May 15, 2023

**Re: Griego Farms at 1860 Griego Rd. NW  
Erosion and Sediment Control Plan  
Engineer's Stamp Date 5/8/23 (F13E028A)**

LANDSCAPE
CONSTRUCTION PLAN

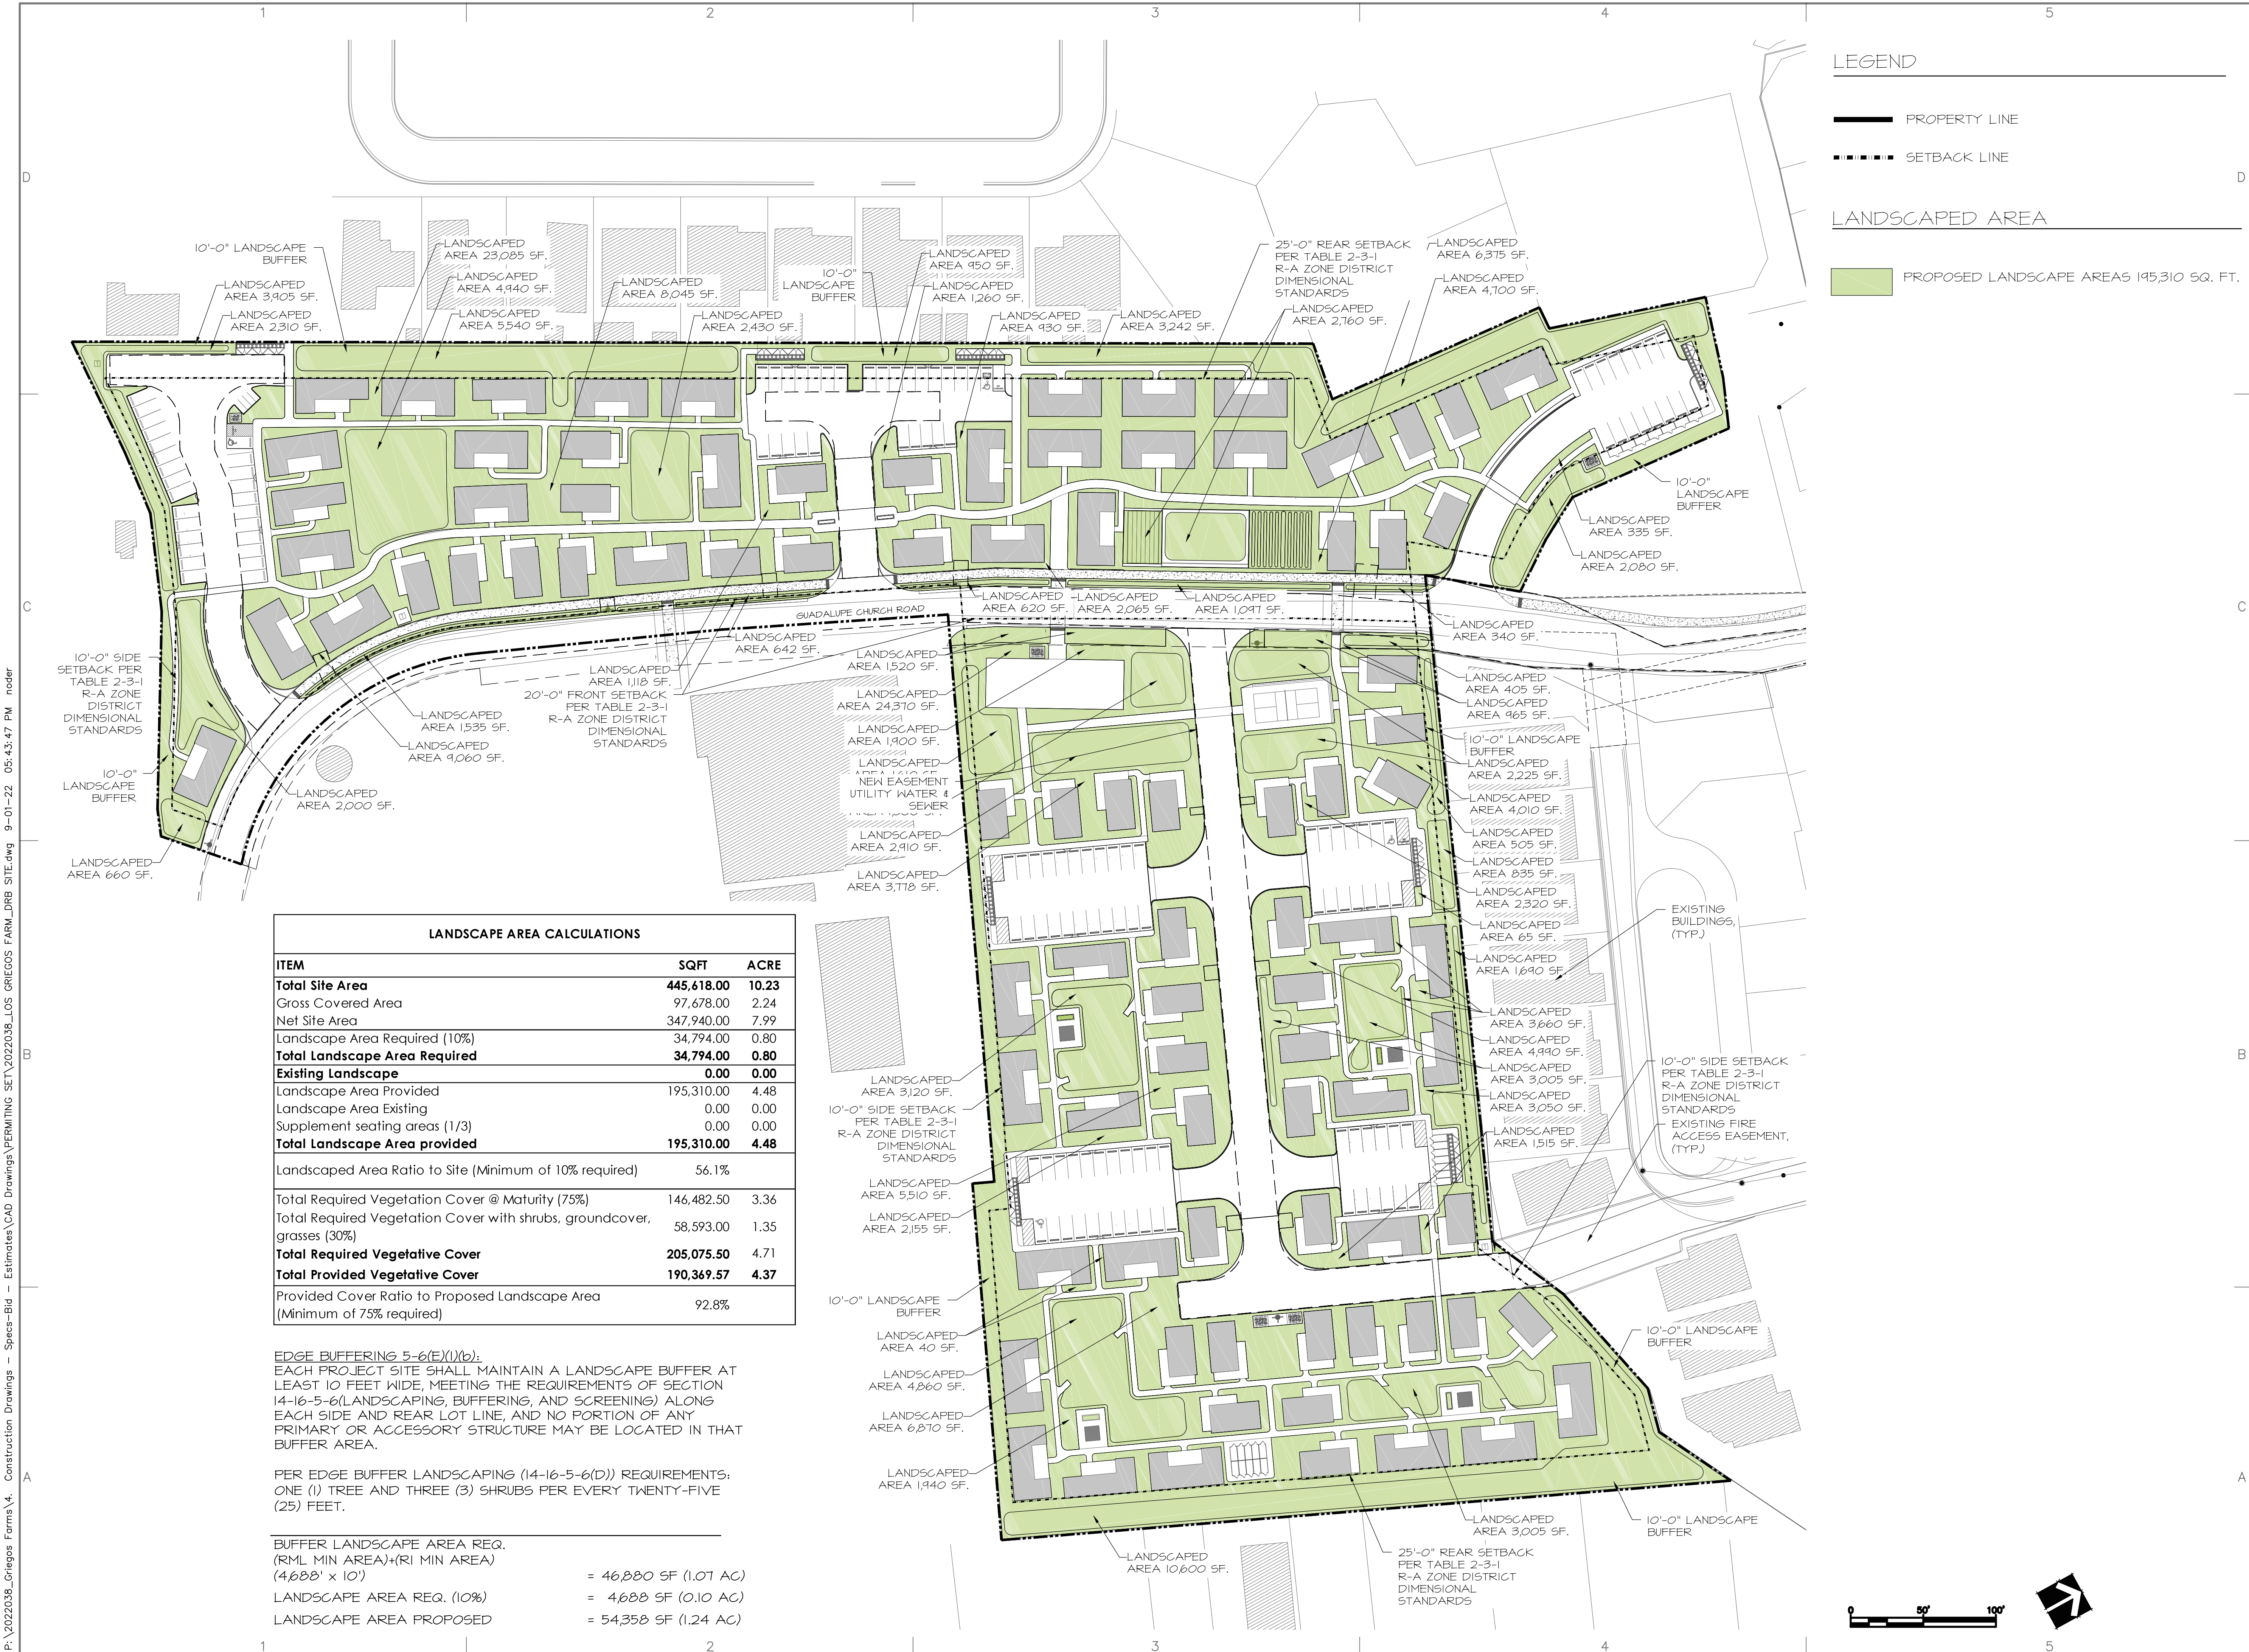
2. There are some inconsistencies in the stabilization specifications that make them difficult to follow. The Landscape Plan has a hatch symbol for the onsite ponds that is labeled "Bio-retention Pond Seed Mix" in the Legend, but I can't find any further description or specification of what is meant by "Bio-retention Pond Seed Mix".

# Temporary Erosion and Sediment Control Plan

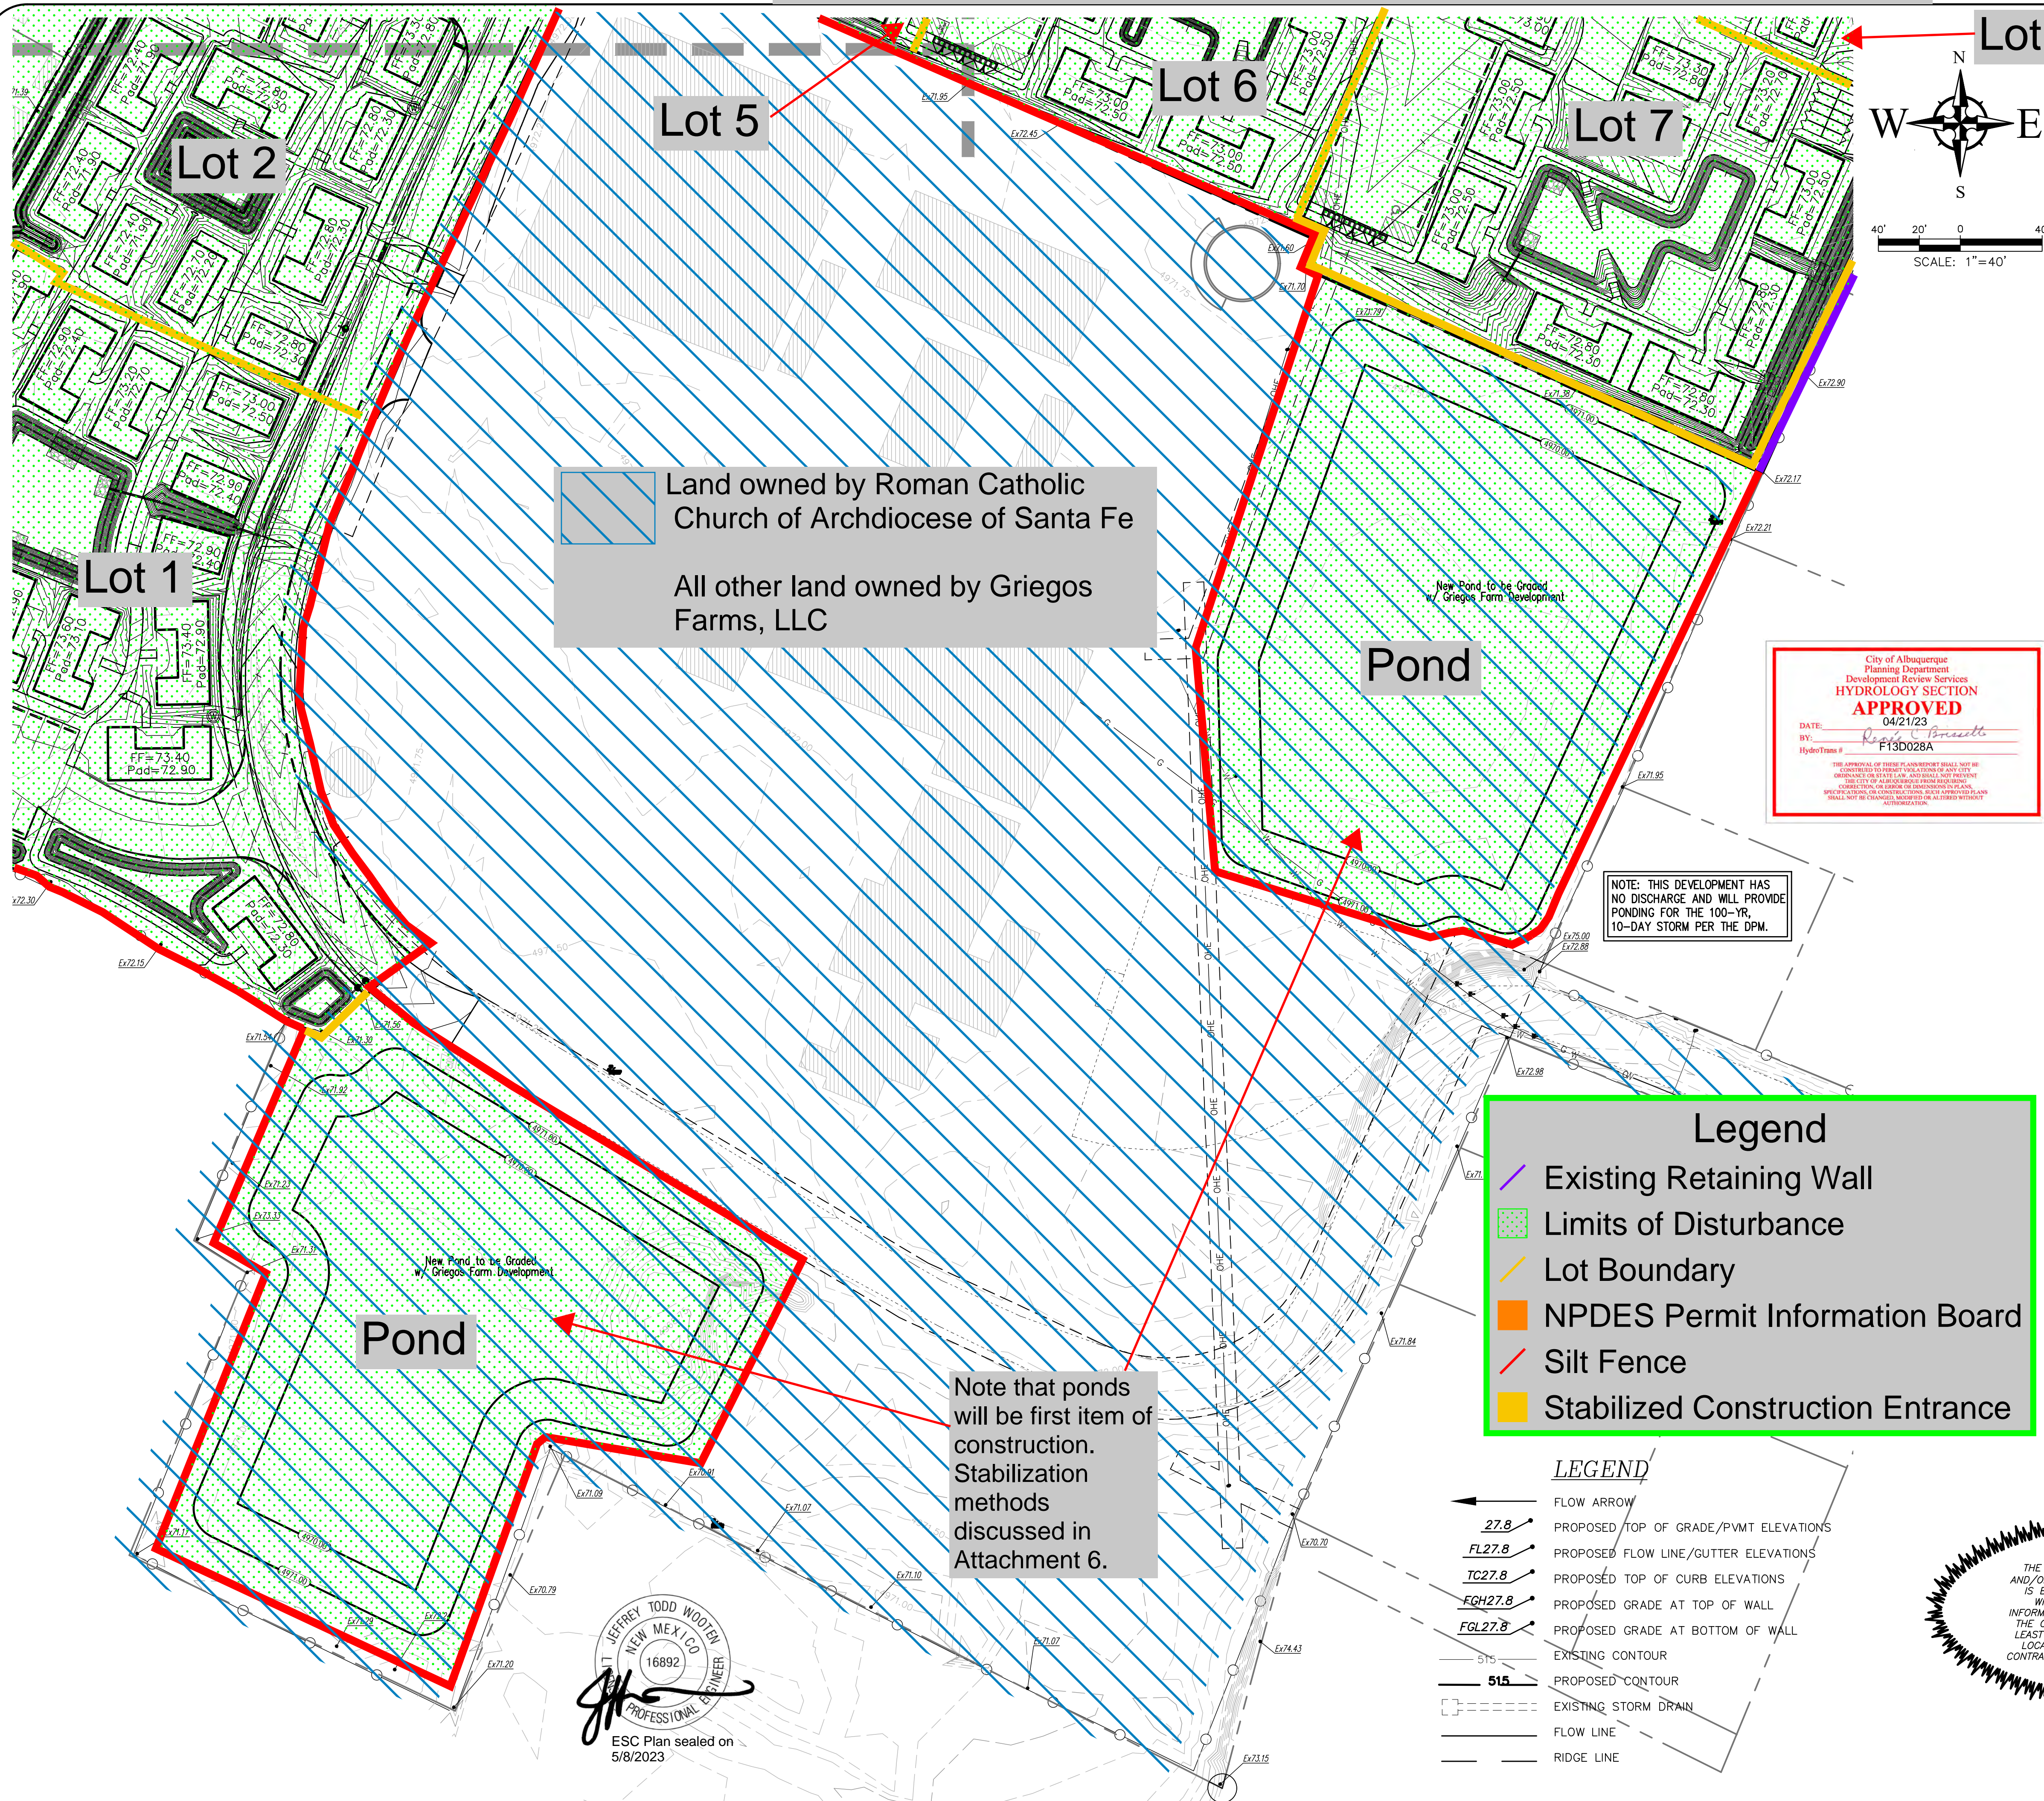
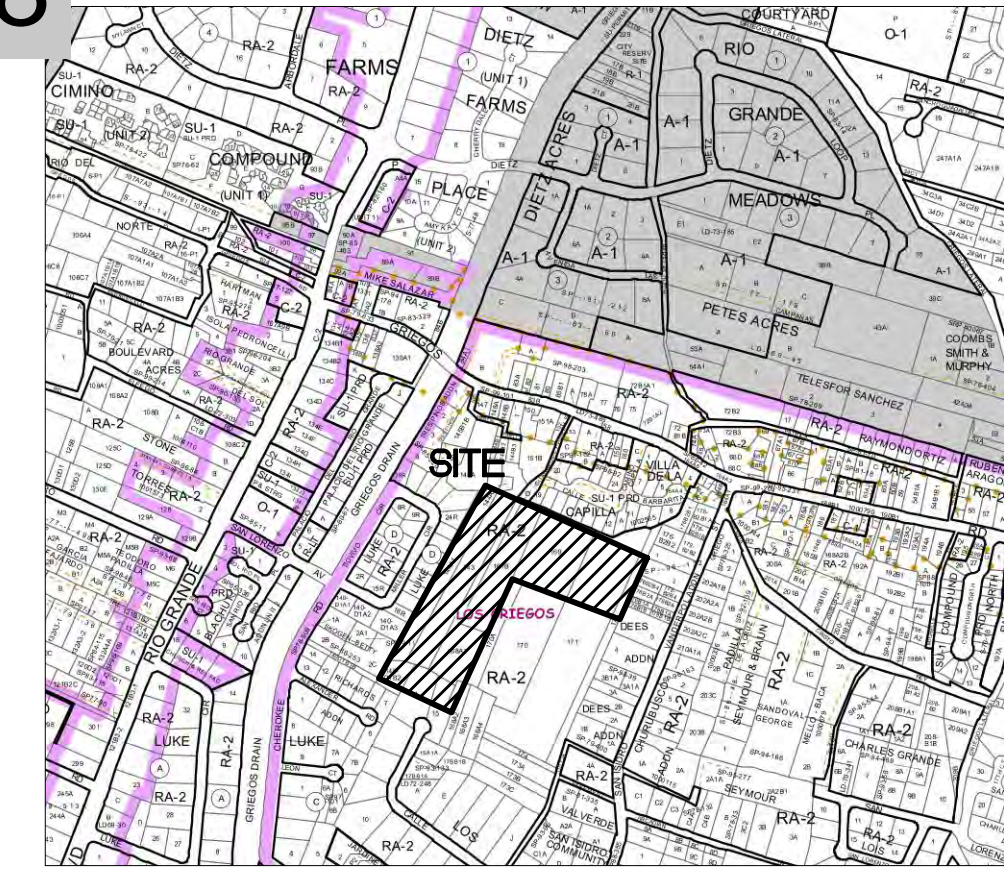
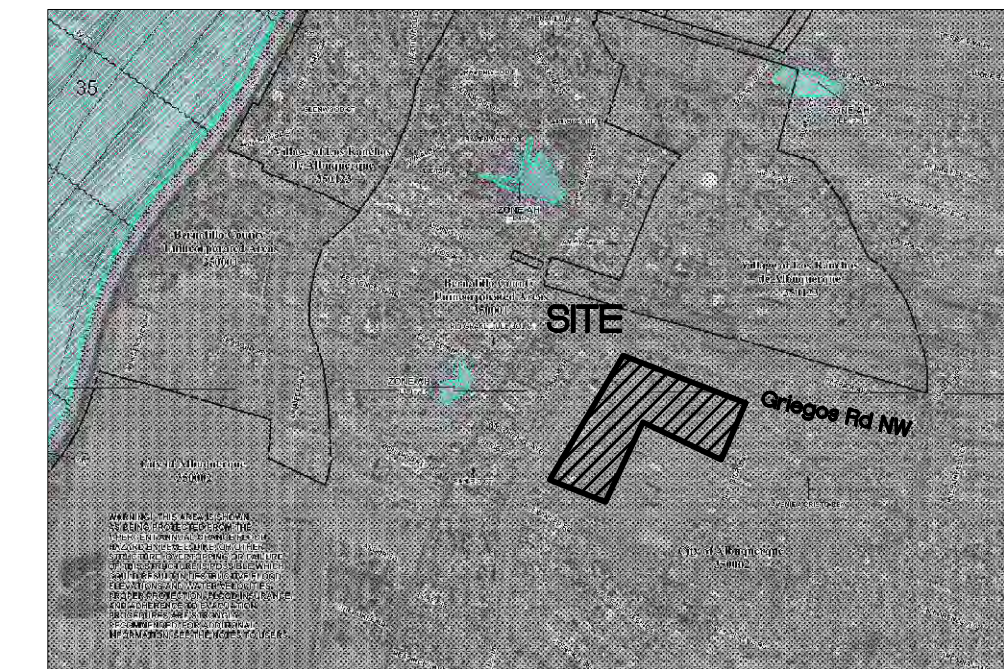
to the plans to use the specifications. The reference in the note on the two church ponds on the ESC Sheets should be clarified. It should reference a concise specification. Add construction notes to the ESC Plan to clearly indicate which ponds the "Pond Stabilization Specifications" will be used on?
